Your Ref
P/84/12/
Our Ref
PLAN-001616
Date
20/11/2012

Proposal: New access road & amendment to curtilage of Plot 1 - amendment to approval P/44/09/ (re-submission following refusal P/30/12/).
Site: Car Park Land off Sandy Road, Pagham PO214SP.
P/84/12/

SOUTHERN WATER

site layout

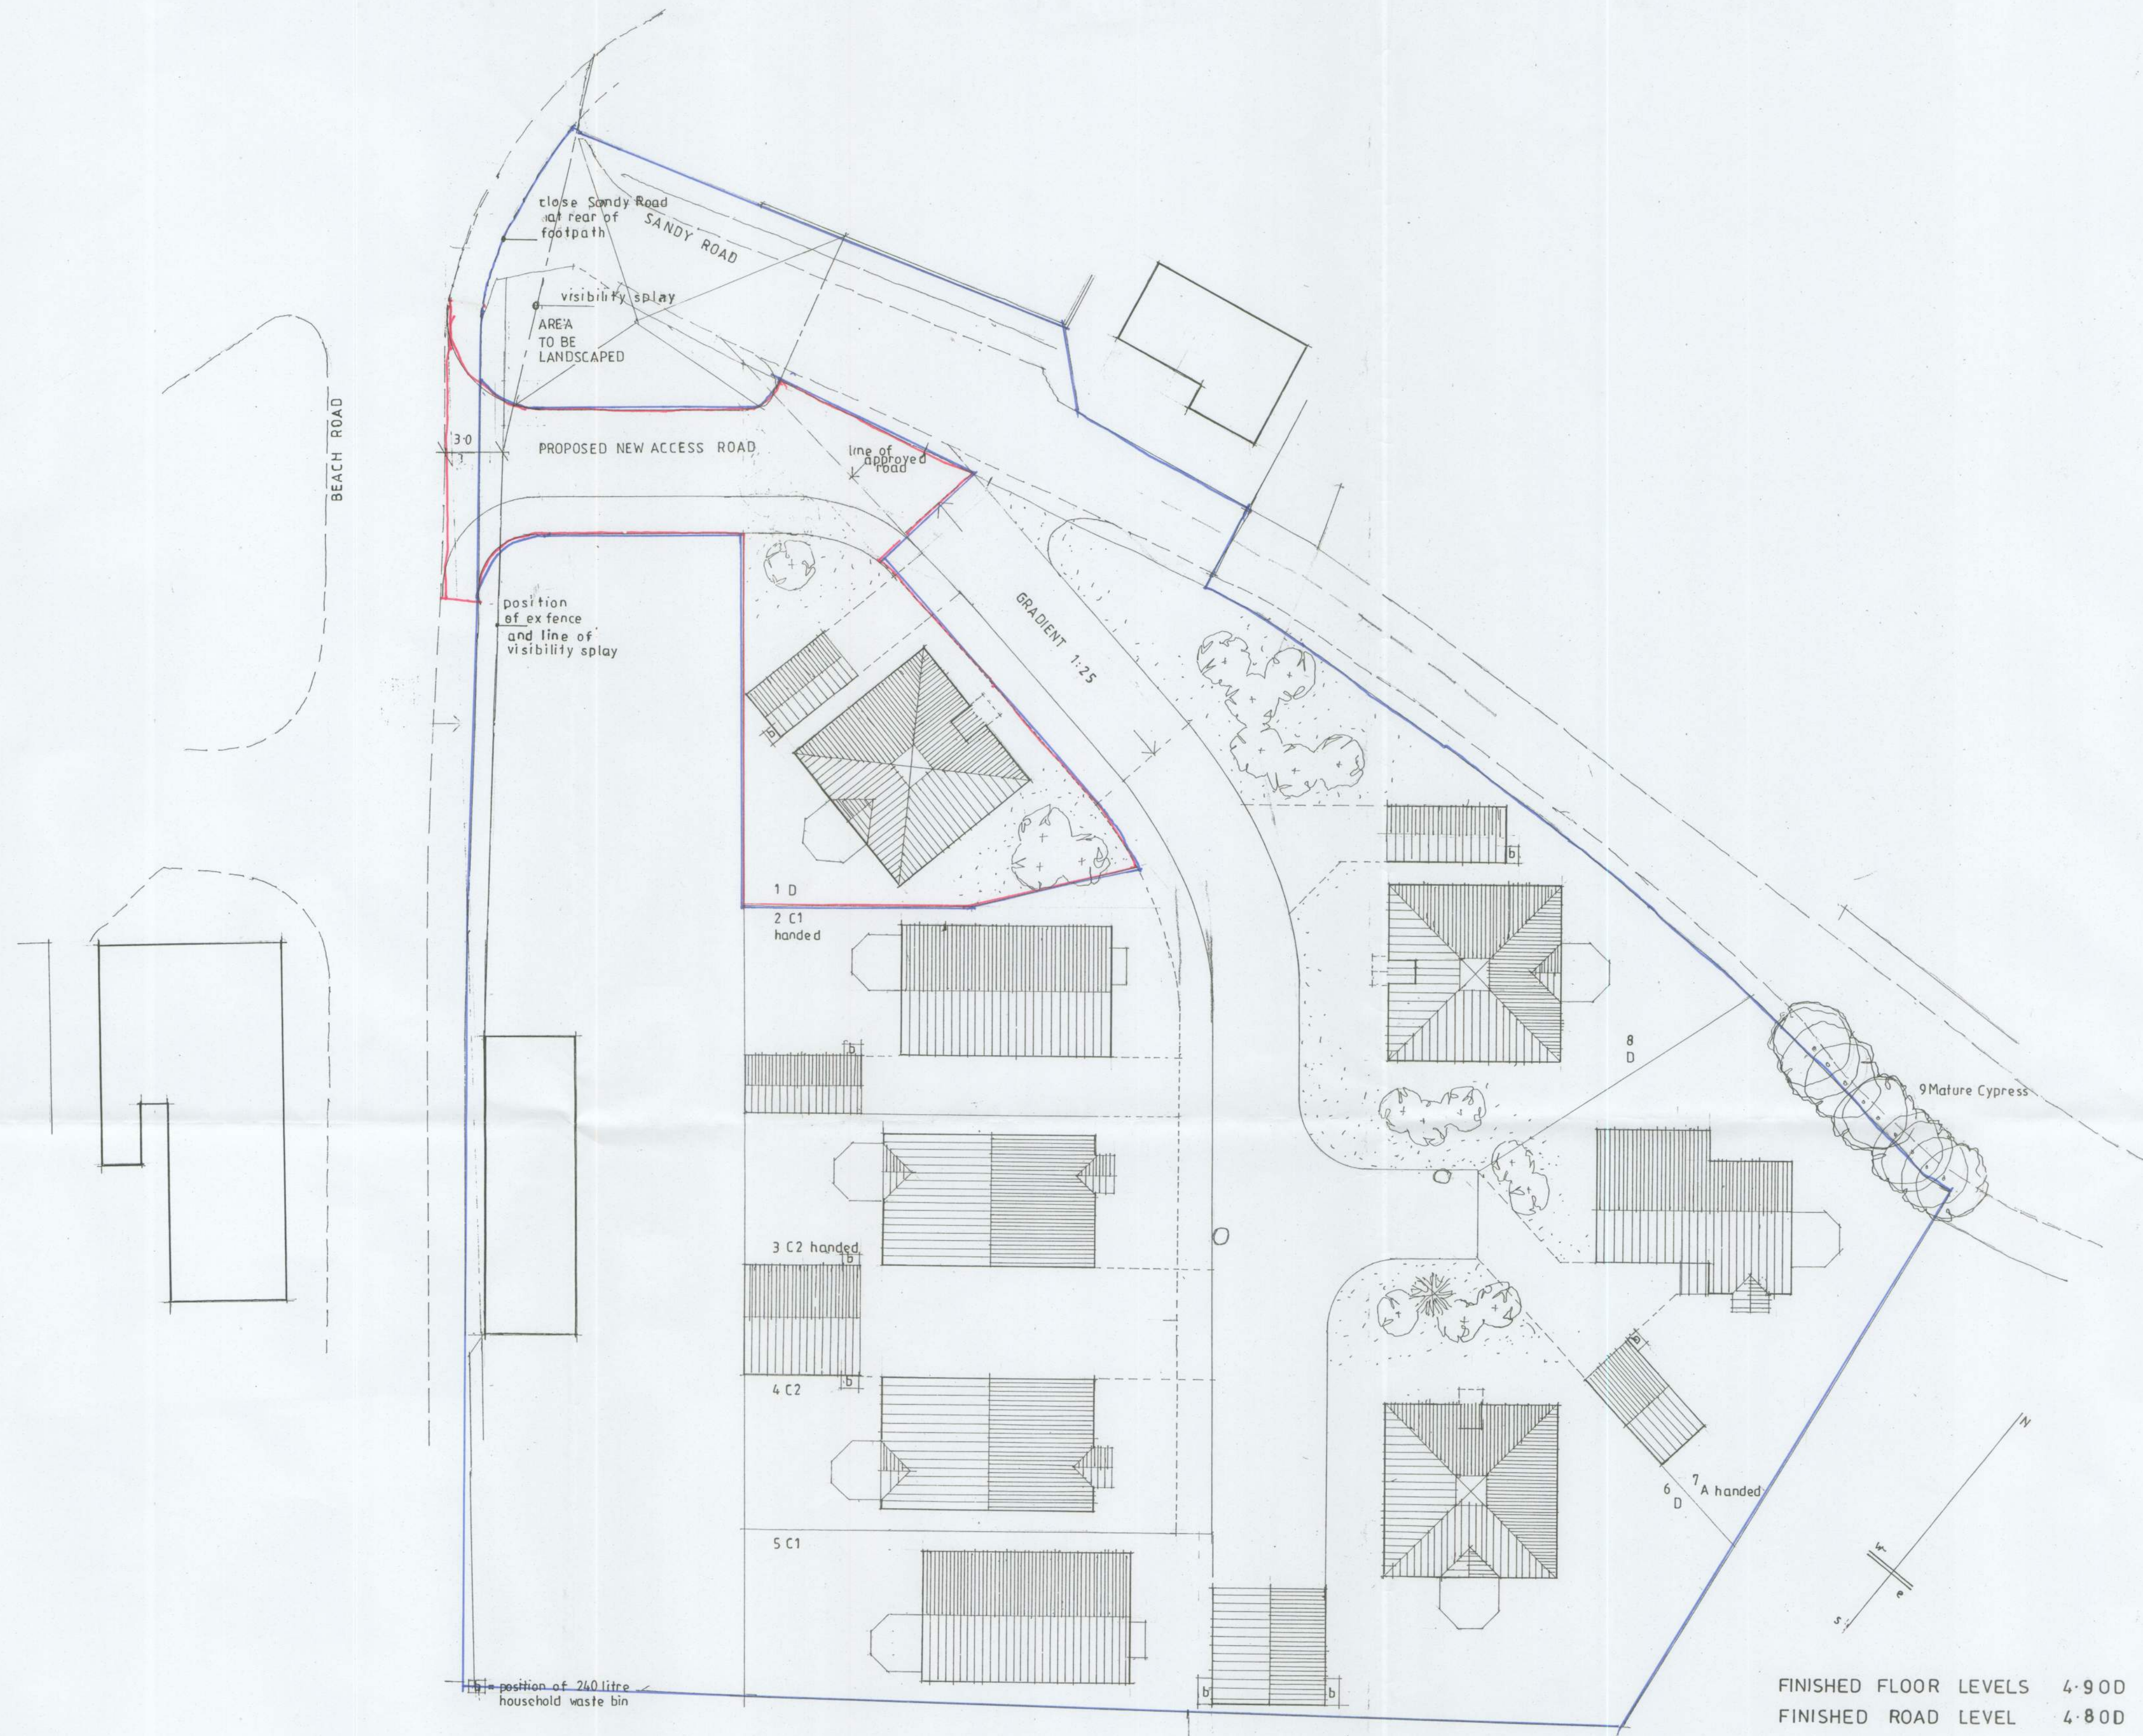
Please find attached a plan of the sewer records showing the approximate position of a foul rising main and foul sewer in the access of the site. The exact position of the foul rising main and foul sewer must be determined on site by the applicant before the layout of the proposed development is finalised.

- No new soakaways should be located within 5 metres of a public sewer.
- No development or new tree planting should be located within 3 metres either side of the centreline of the foul rising main and foul sewer respectively and all existing infrastructure should be protected during the course of construction works.
